Application No: H14-0173-21 **Applicant:** Mr & Mrs G Kitchen

Proposal: Details of external doors, windows, roof lights and meter boxes and flues etc (Conditions 6, 7, 9 and 11 of H14-1171-19)

Location: Enderby Barns Leaves Lake Drove West Pinchbeck

plan view onto conservation type rooflight
colour to be anthracite grey (factory finish)

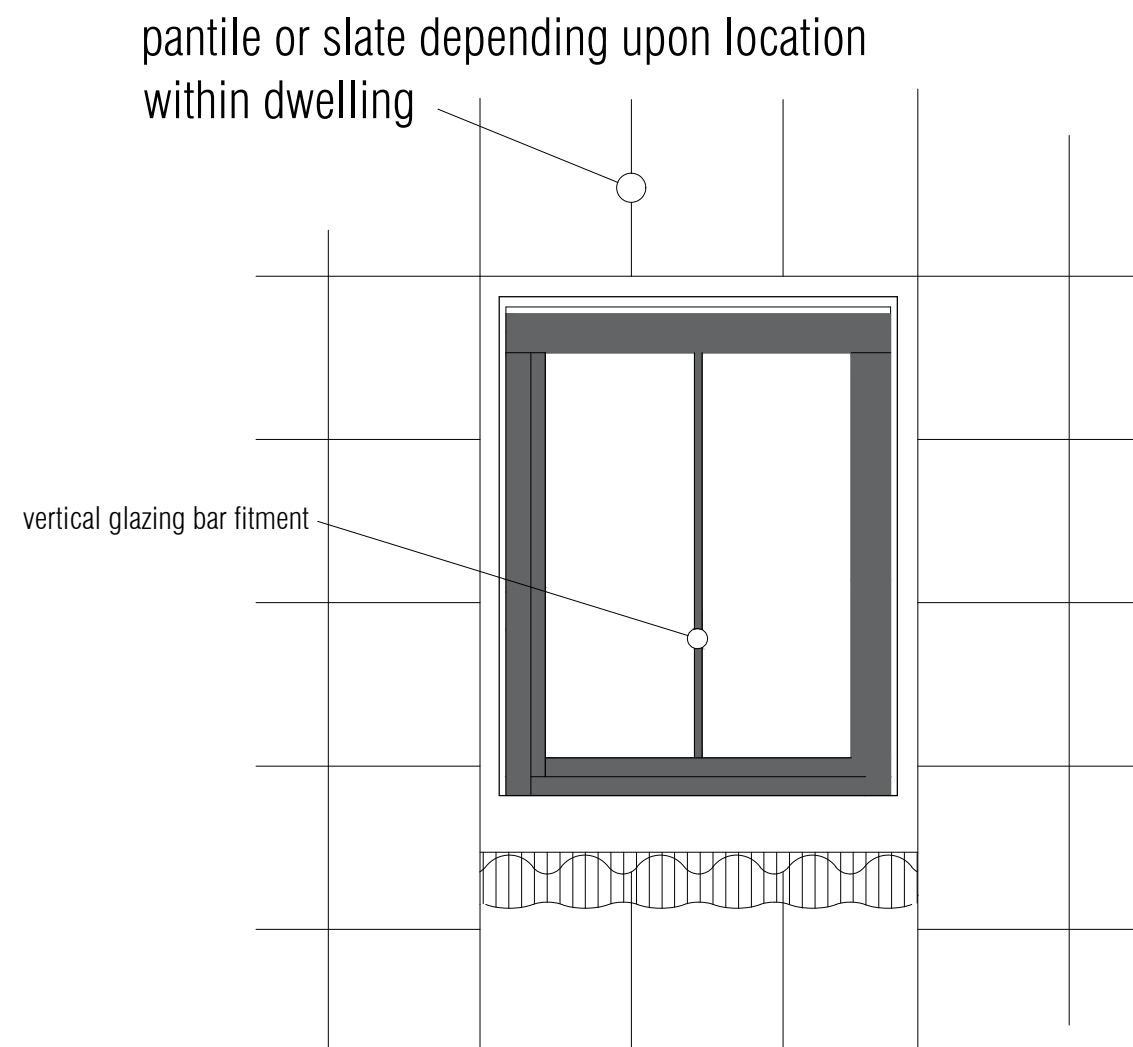
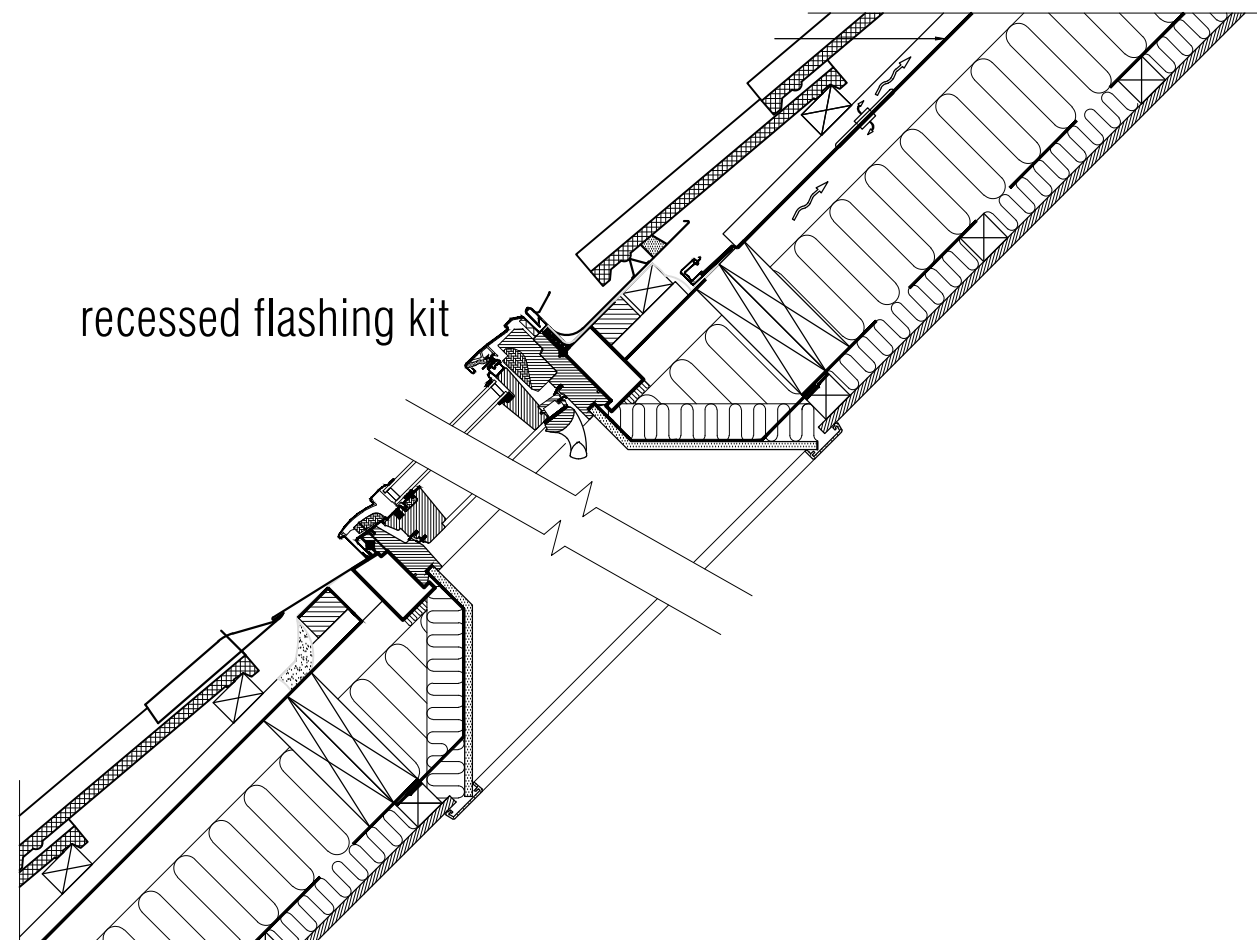
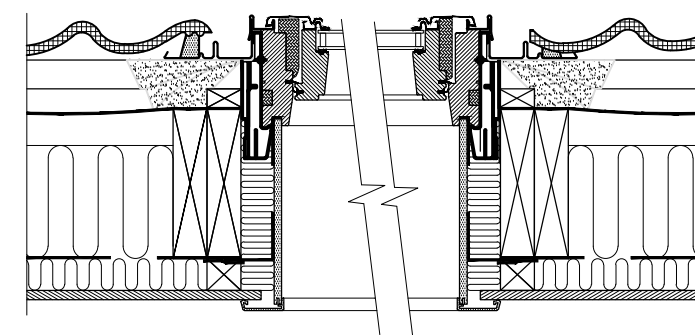
The proposed rooflights are to be anthracite grey with a vertical glazing bar fitment. The proposed

details are considered to be appropriate for the site.

Condition 9 is now considered to have been addressed.

elevation

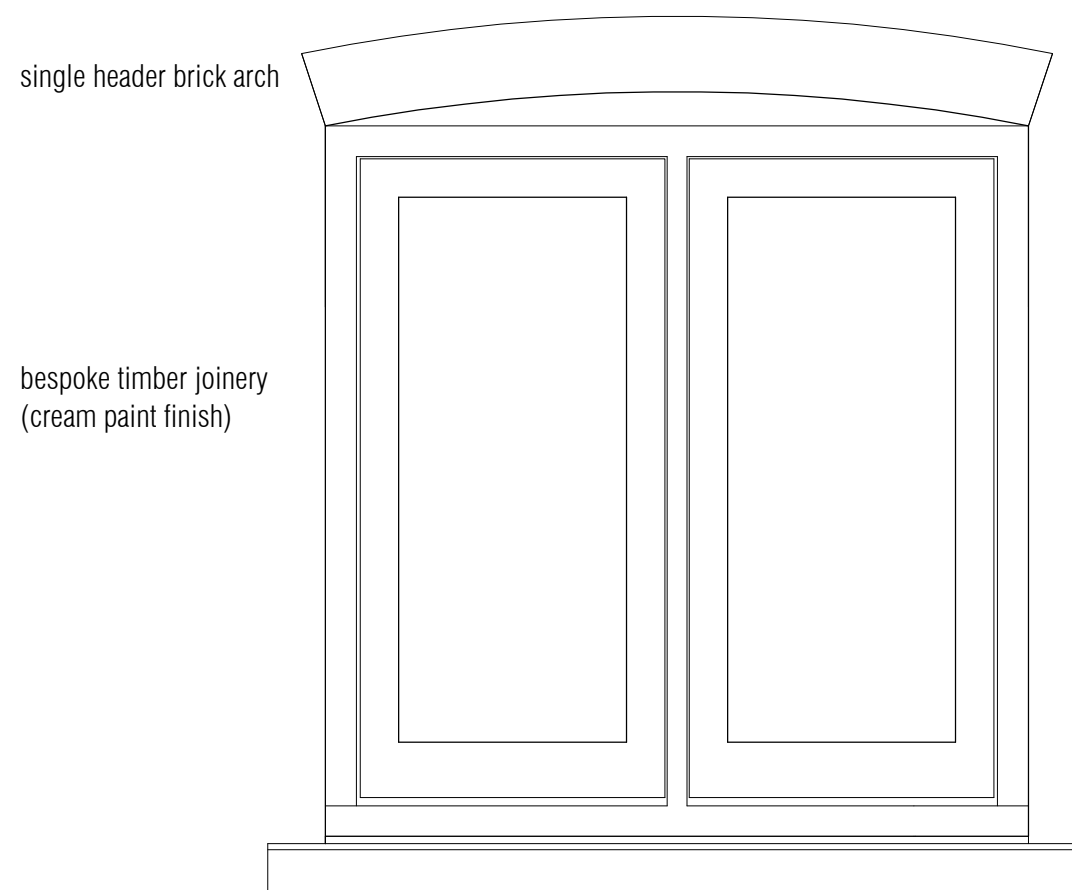
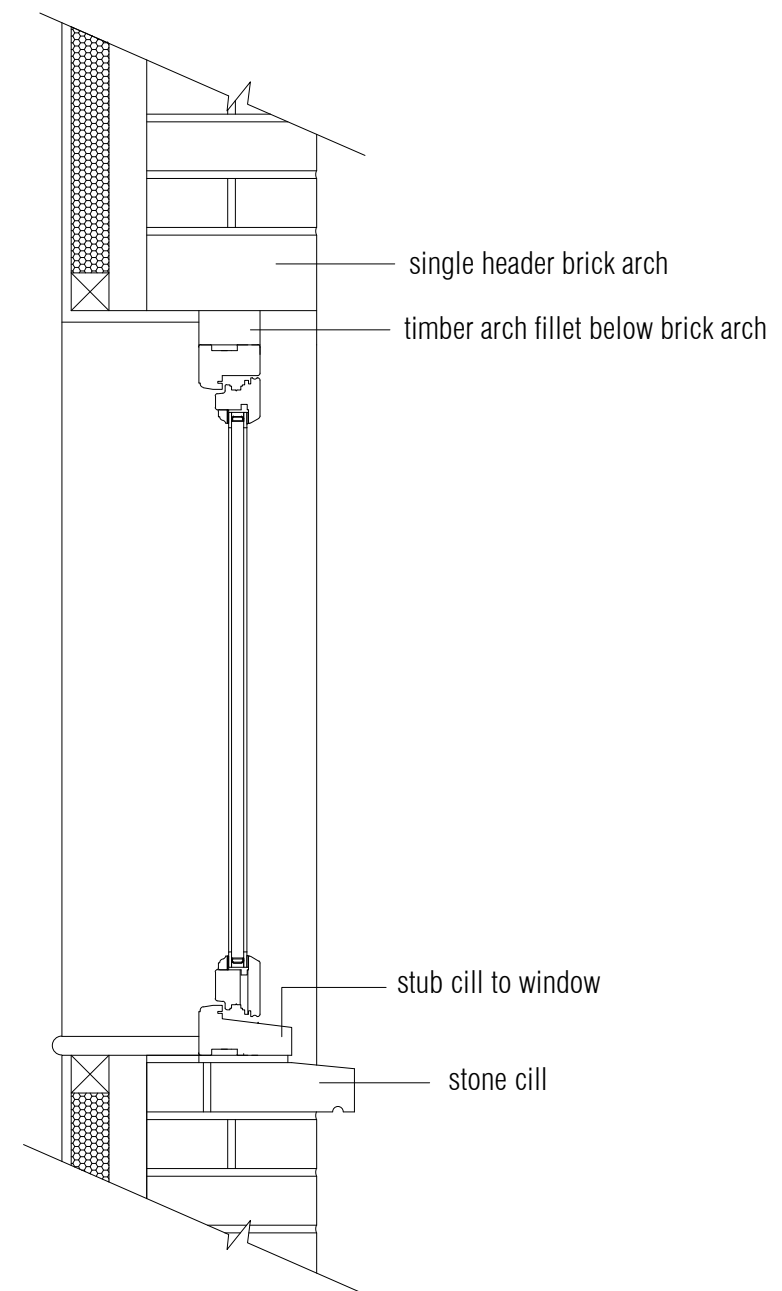
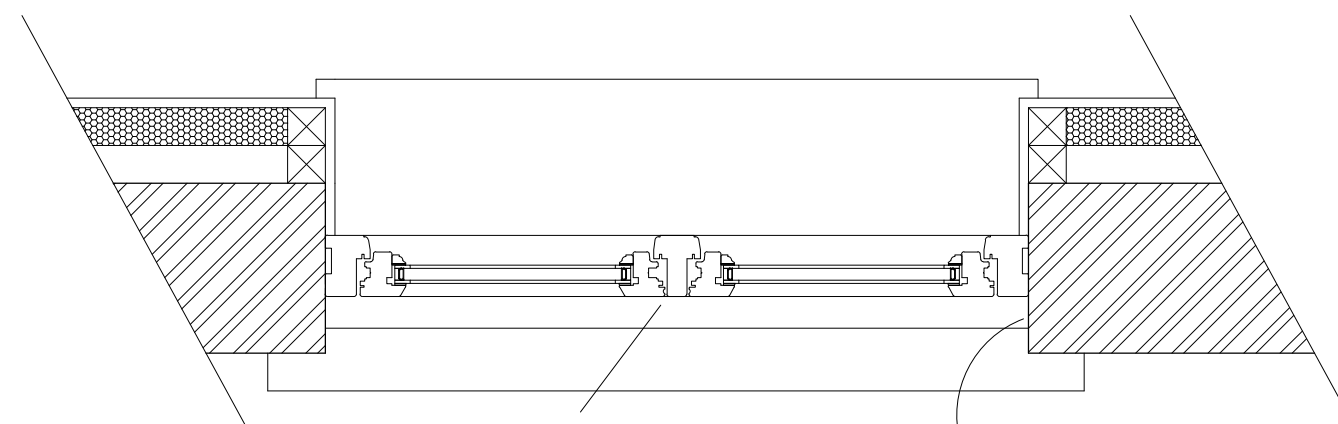
The submitted window details show cream painted timber with a single header brick arch. There is to be a stone cill beneath the window and 75mm reveals. The proposed details are considered to be appropriate for the site.

Condition 7 is now considered to have been addressed.
